National Grid has issued a paper entitled “Document: 8.4.12.2 Response to ISH2 Action Point 27 – Masterplans” – Planning Inspectorate Reference: EN020027. Appendix D is supposed to show opportunities close to the EACN at Ardleigh, and purporting to set out plans to introduce tree planting and other mitigants. The owners of the Grade 2 Listed Heritage Asset, [REDACTED] Farm, situated in Hungerdown Lane, Ardleigh, and with a boundary just 10 metres away from National Grid’s boundary (order limits) are, once again, extremely concerned to note the lack of any form of realistic mitigation. [REDACTED] Farm is shown as having a border of woodland on two of its boundaries – this is correct, and was planted by the current owners approximately 35 years ago. However, it should be noted that the trees are 95% deciduous, and will provide no protection against noise pollution during the winter months. They will also provide no mitigation against the five 50 metre high pylons that will loom over this Grade 2 Heritage Asset (Pylons TB1, TB2, TB3, TB4 and TB5). And this is after National Grid has referred to [REDACTED] Farm in its Vol.6 Environmental Statement, 14.7 Operational Noise Assessment, P.

Action Point 27: Ardleigh & Little Bromley – Draft Opportunities Plan

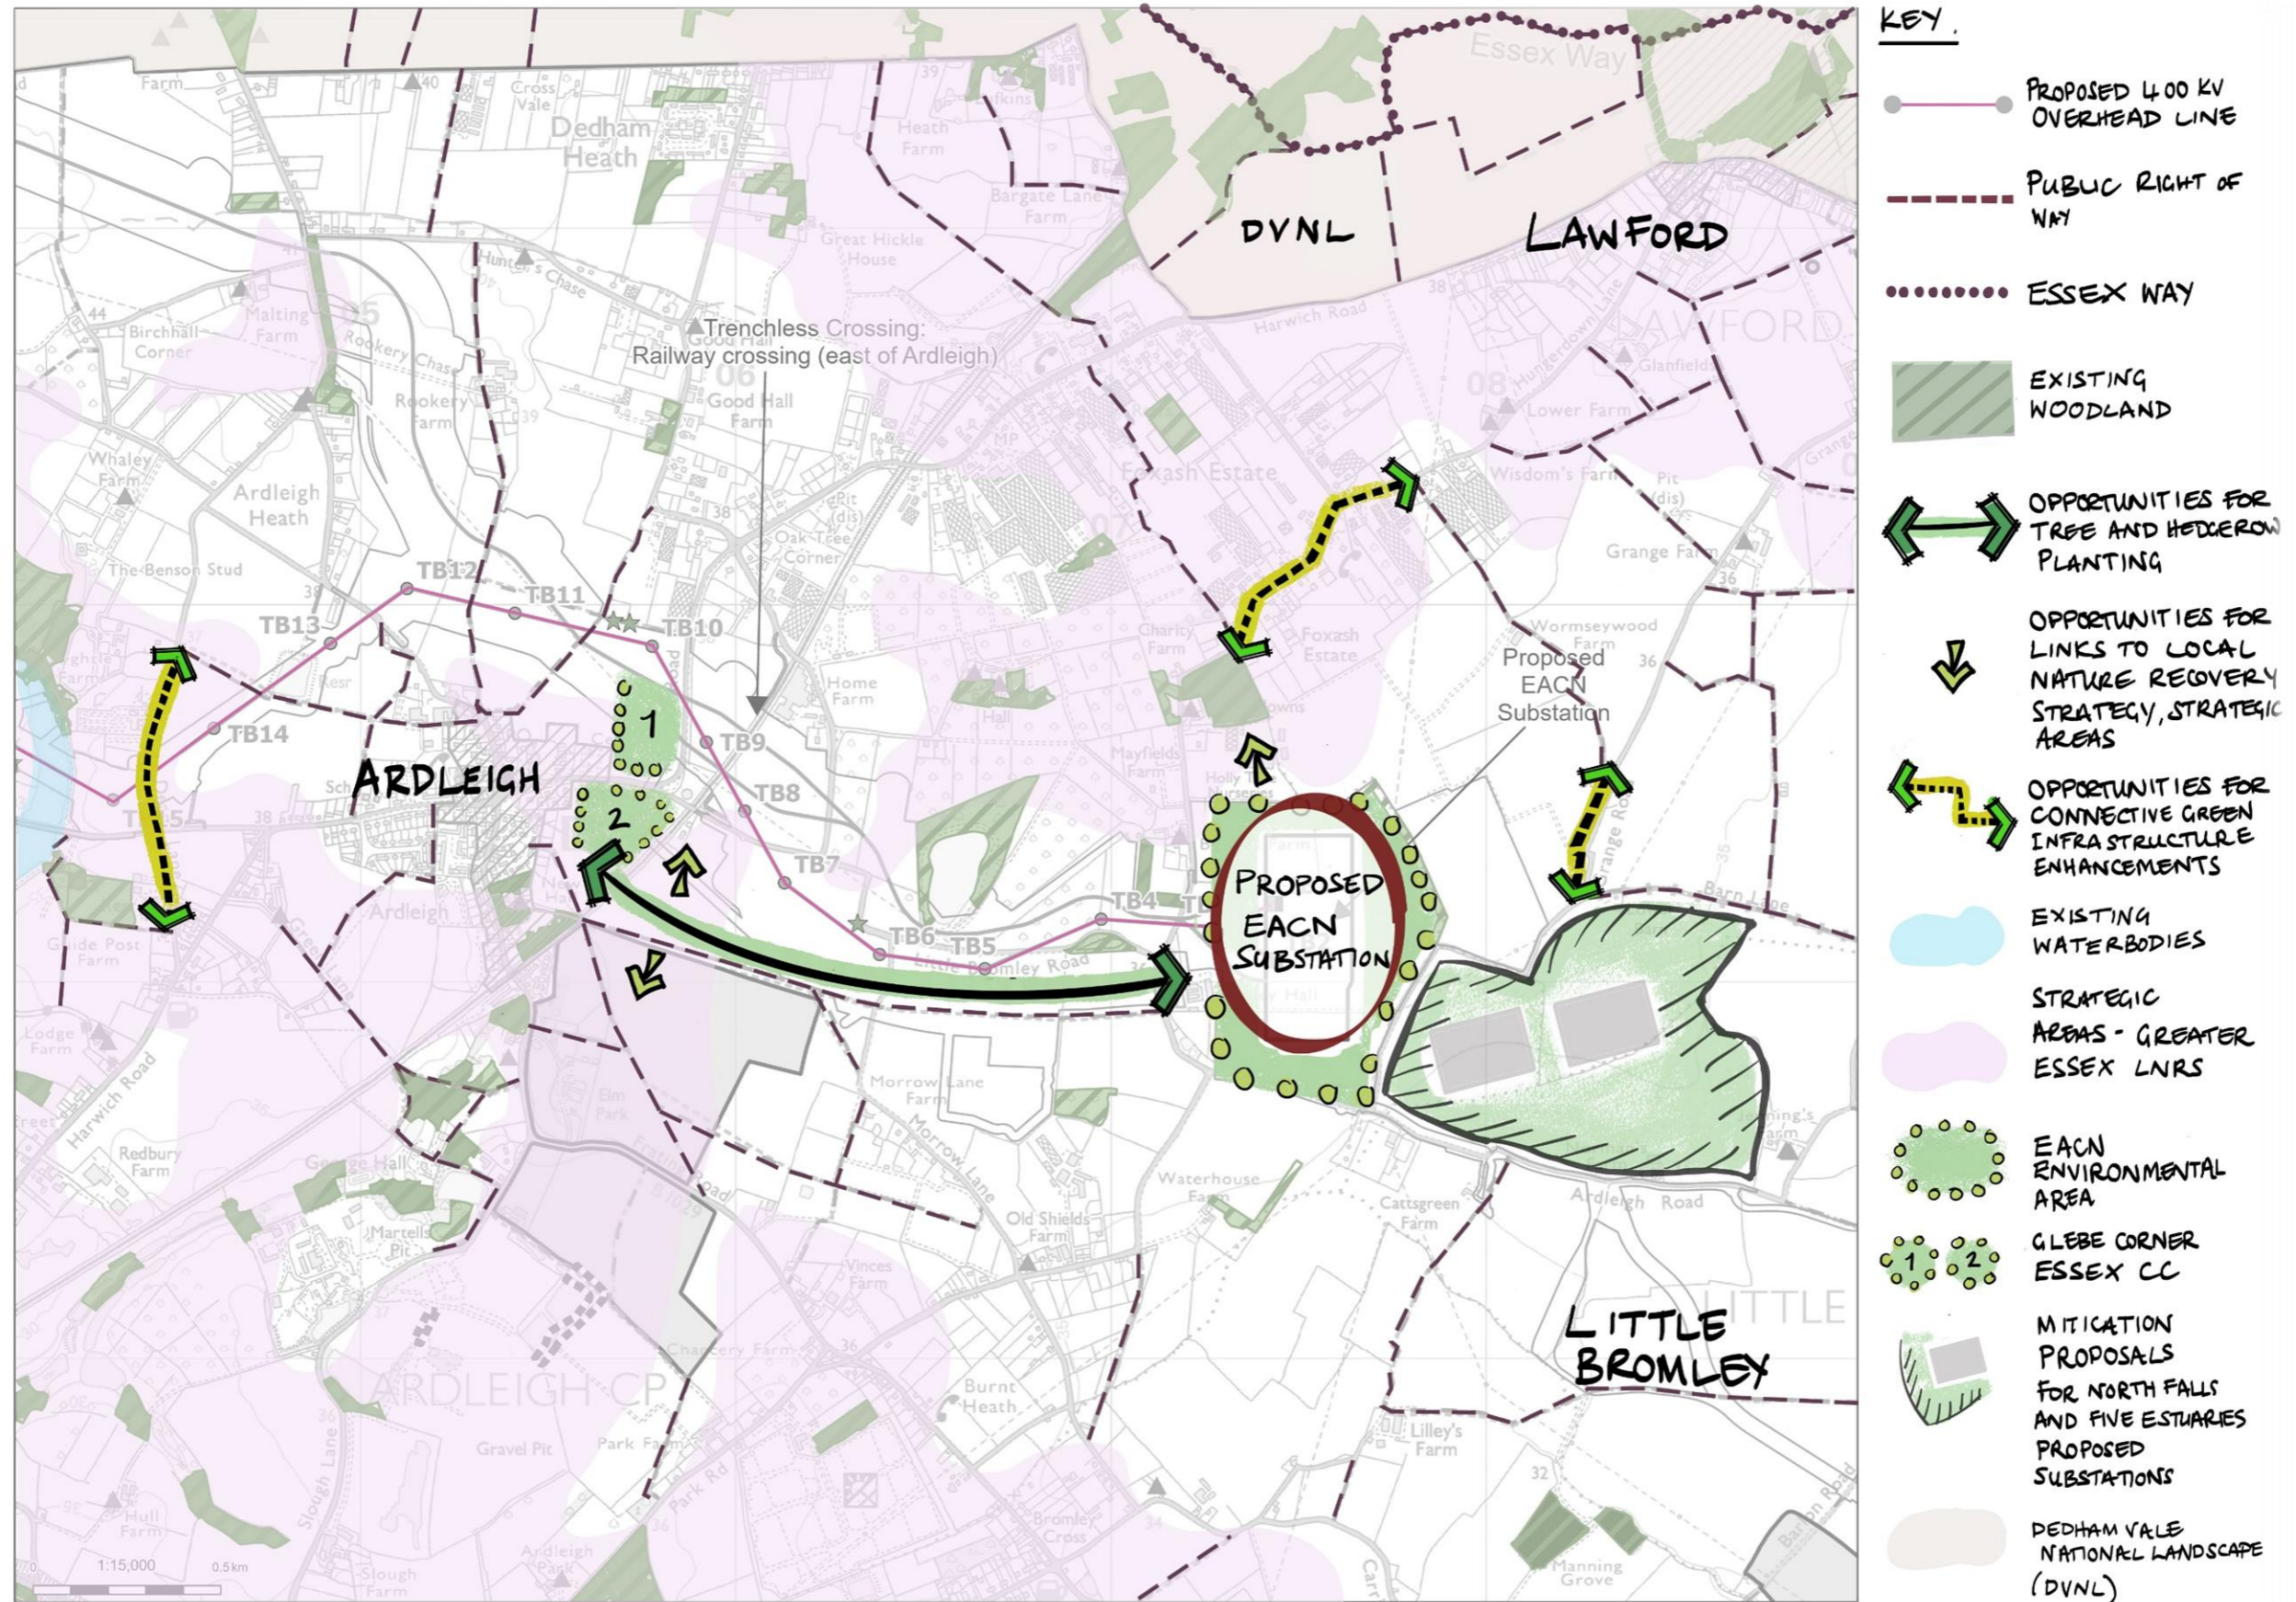
The proposed EACN substation is shown on National Grid’s “Action Point 27: Ardleigh and Little Bromley – Draft Opportunities Plan” as being surrounded by the EACN Environmental Area. As this Environmental Area is immediately opposite, extremely close to and in full view of the Grade 2 Heritage Asset, [REDACTED] Farm, the EACN Environmental Area should be specifically stated. To call it just the “EACN Environmental Area” and to show a pretty picture with green colouring is far too woolly.

Heading north from the proposed EACN Substation site, and directly towards the wood belonging to the Grade 2 Heritage Asset, Hungerdowns, there is an arrow which indicates “opportunities for links to local nature recovery strategy, strategic areas.” This will directly take in the land belonging to a business, Holly Tree Nurseries. Has any effort been made to consult with the owners of this business? Have they been made fully aware of NG’s proposed plans? It is highly unlikely.

Heading north east from the north east corner of the wood belonging to Hungerdowns there is an arrow which indicates “opportunities for connective green infrastructure enhancements.” What a curious form of mitigation! Is National Grid aware that this area of Hungerdown Lane consists of 30-40 individual properties? These properties mostly already have mature hedges facing the lane, and it is difficult to see what further mitigation NG is proposing. If NG proposes to place “connective green infrastructure” further away from the lane this seems ambitious, if not impracticable. It would require negotiating with 30-40 landowners to give up part of the back gardens, so that the “connective green infrastructure” could be created. In addition some of the owners run businesses from the properties, such as organic vegetable supplies and equestrian centres. This strongly suggests that NG has failed to do any credible research.

Furthermore the Grade 2 Heritage Asset, [REDACTED] Farm, situated with a boundary of just 10 metres from NG’s boundary and surrounded on nearly 3 sides by NG’s boundary, has been offered no such mitigation. The site of [REDACTED] Farm is immediately opposite, extremely close to and in full view of NG’s proposed EACN substation. What mitigation is NG proposing to offer to the owners of [REDACTED] Farm, and why has it not been included in the “Action Point 27: Ardleigh and Little Bromley – Draft Opportunities Plan?”
